Application no: H08/1313/02

Location: 75 High Street
Gosberton

Amendment: Change from new shop window to brick walls, sash
window & traditional doorway (dwg nos. 02/37/05 & 06)

Additional Comments of Conservation Officer

06

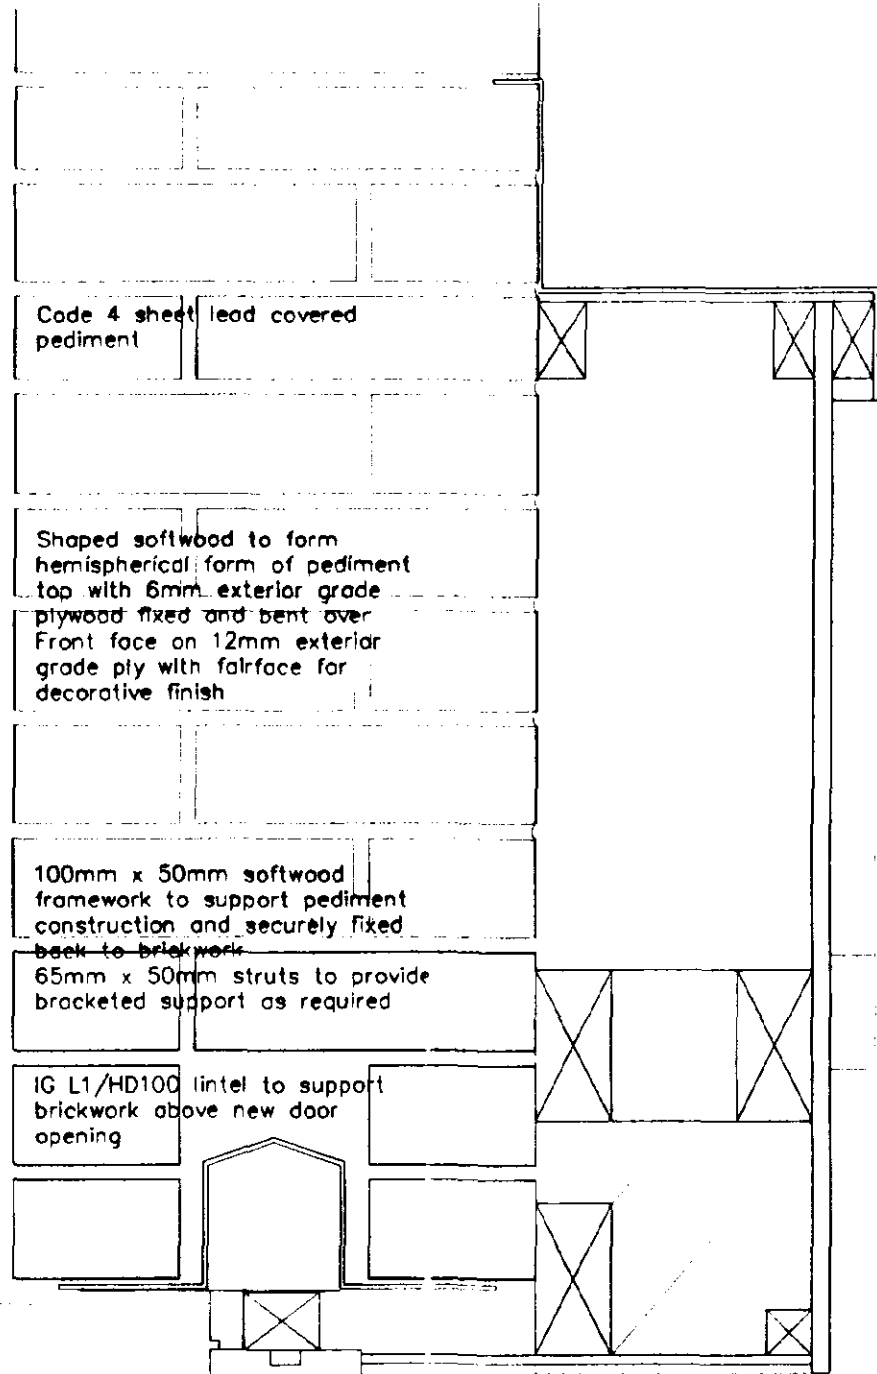
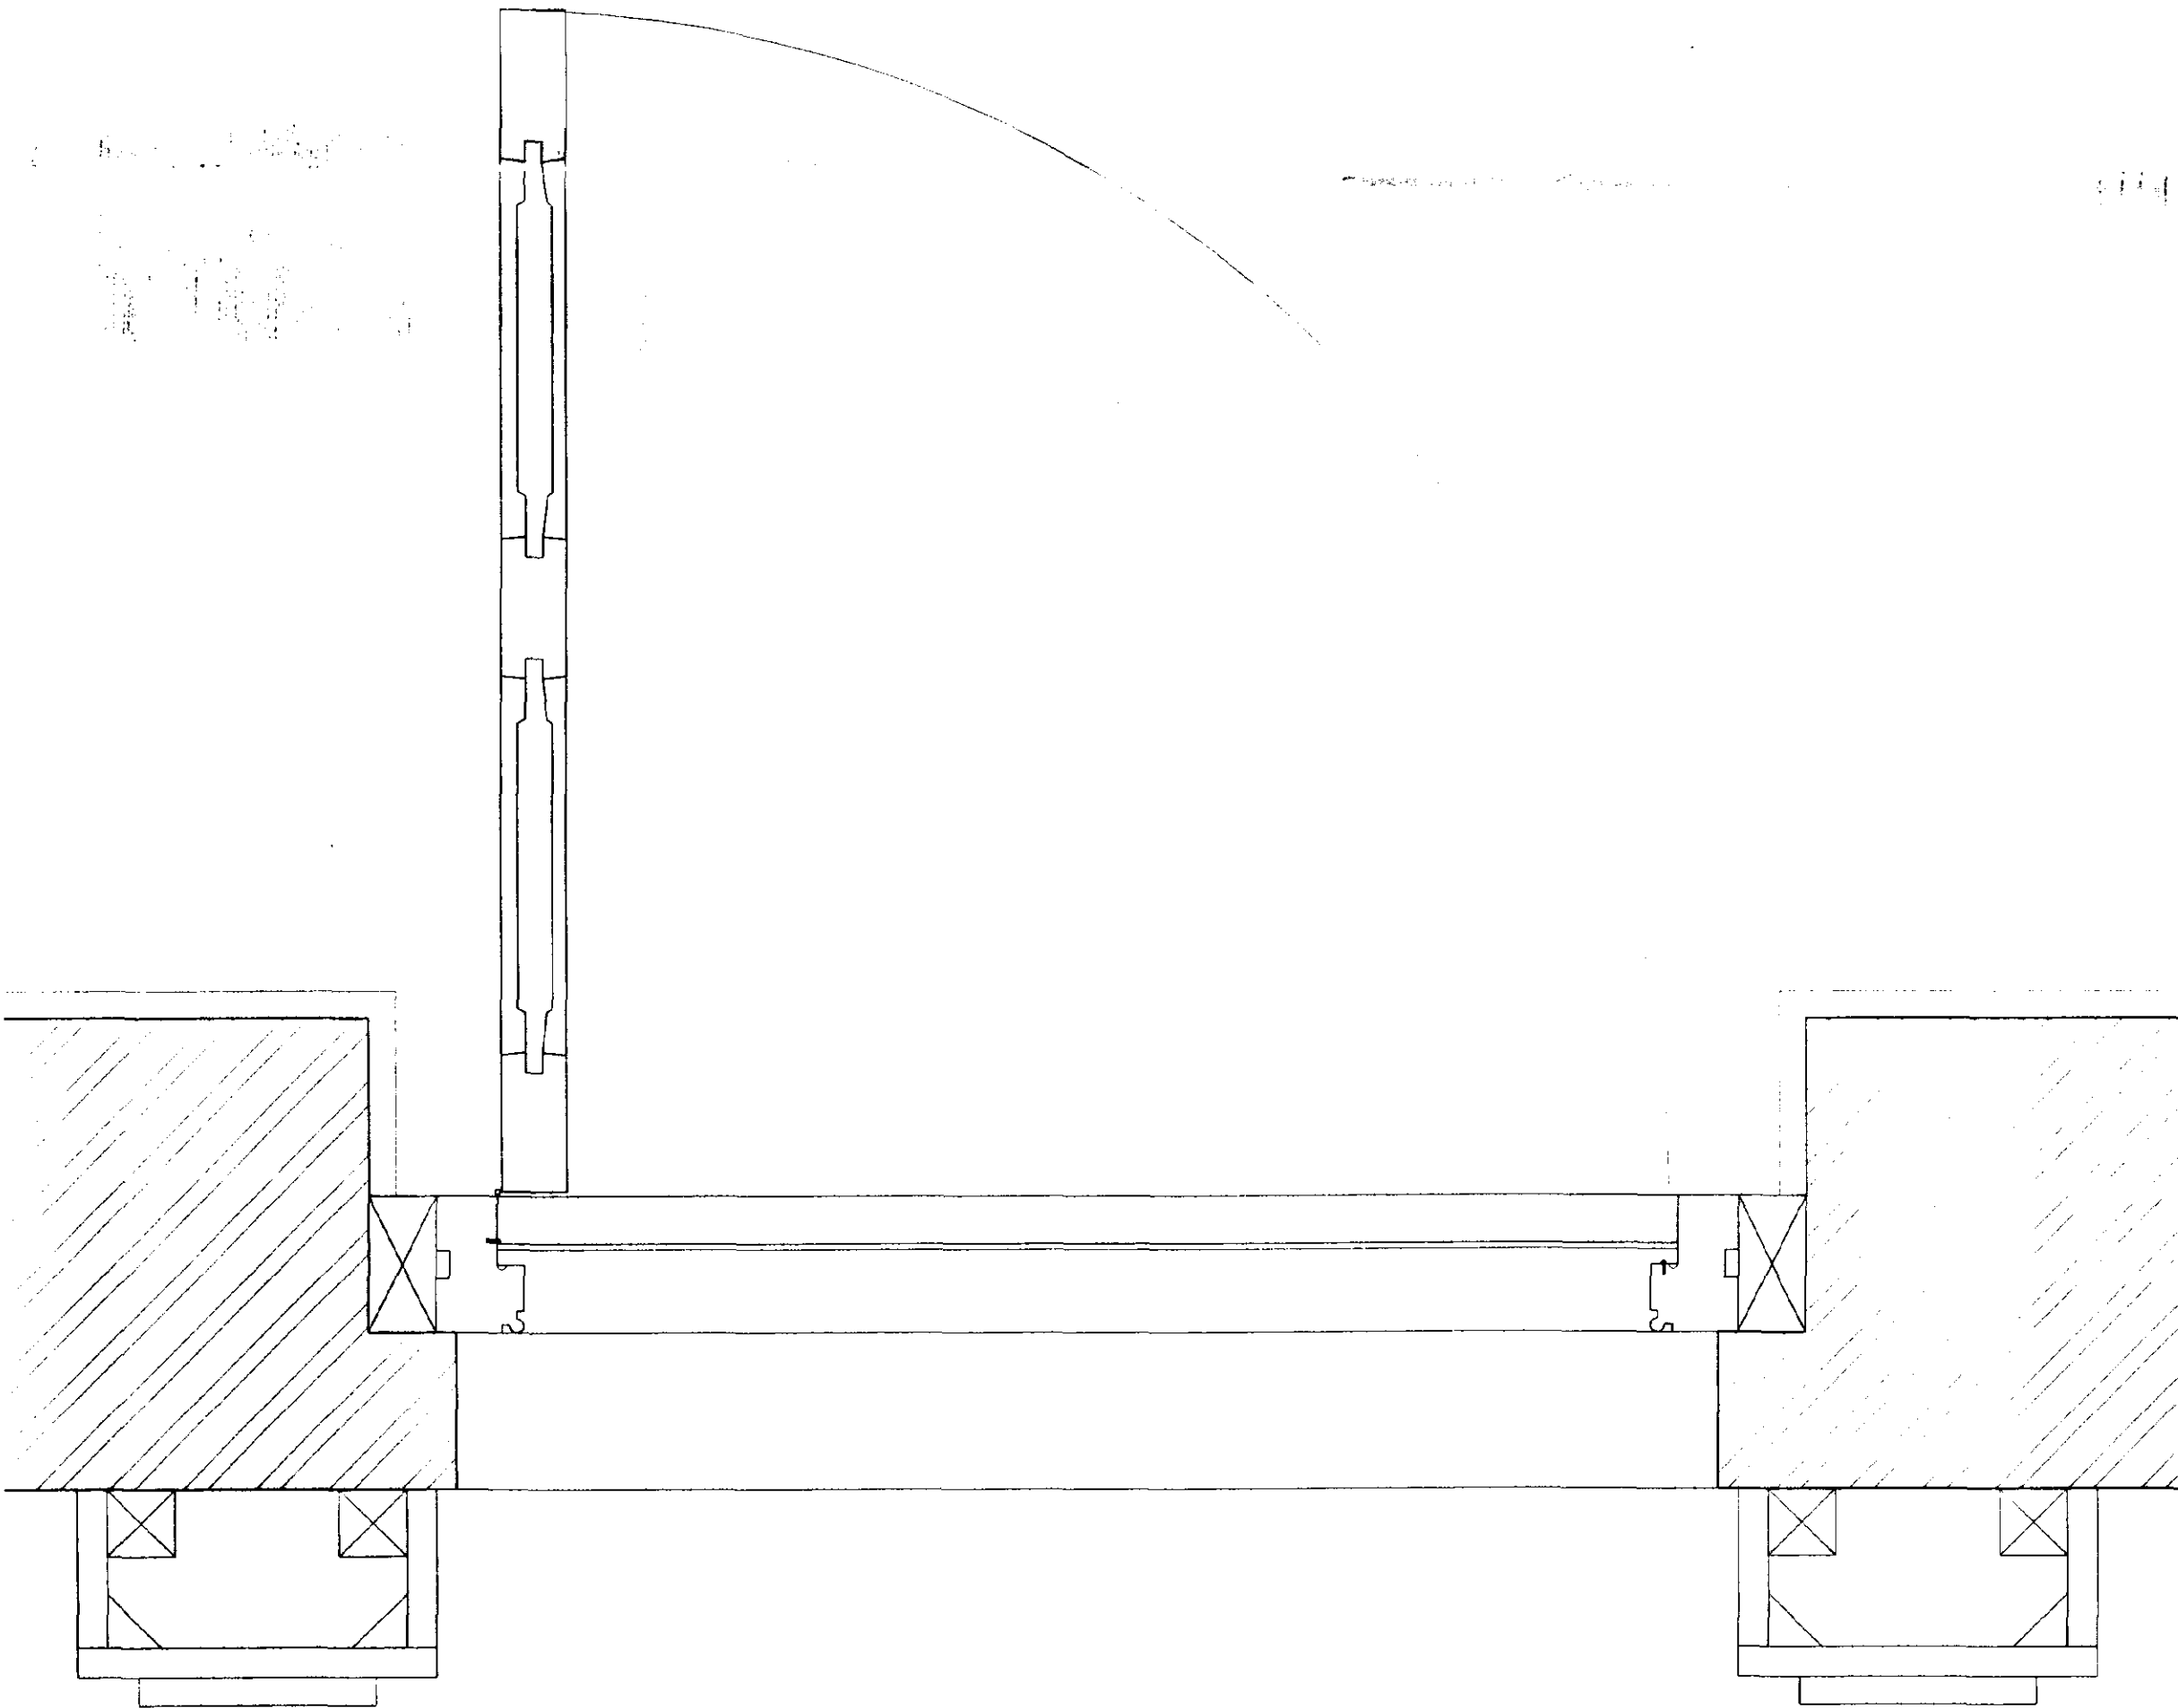
I am happy with the details of the door and window as submitted. I do, however, have some concern over the door surround. The semi circular detail of the pediment is unusual. I have not checked surrounding buildings but none of the listed buildings have this detail. A simple flat entablature would I feel, may be more appropriate. Furthermore, the stark plainness of the pilaster and entablature may well be wrong for the area. I suggest that the applicant be asked to look at the details of nearby door surrounds for a suitable copy to be replicated.
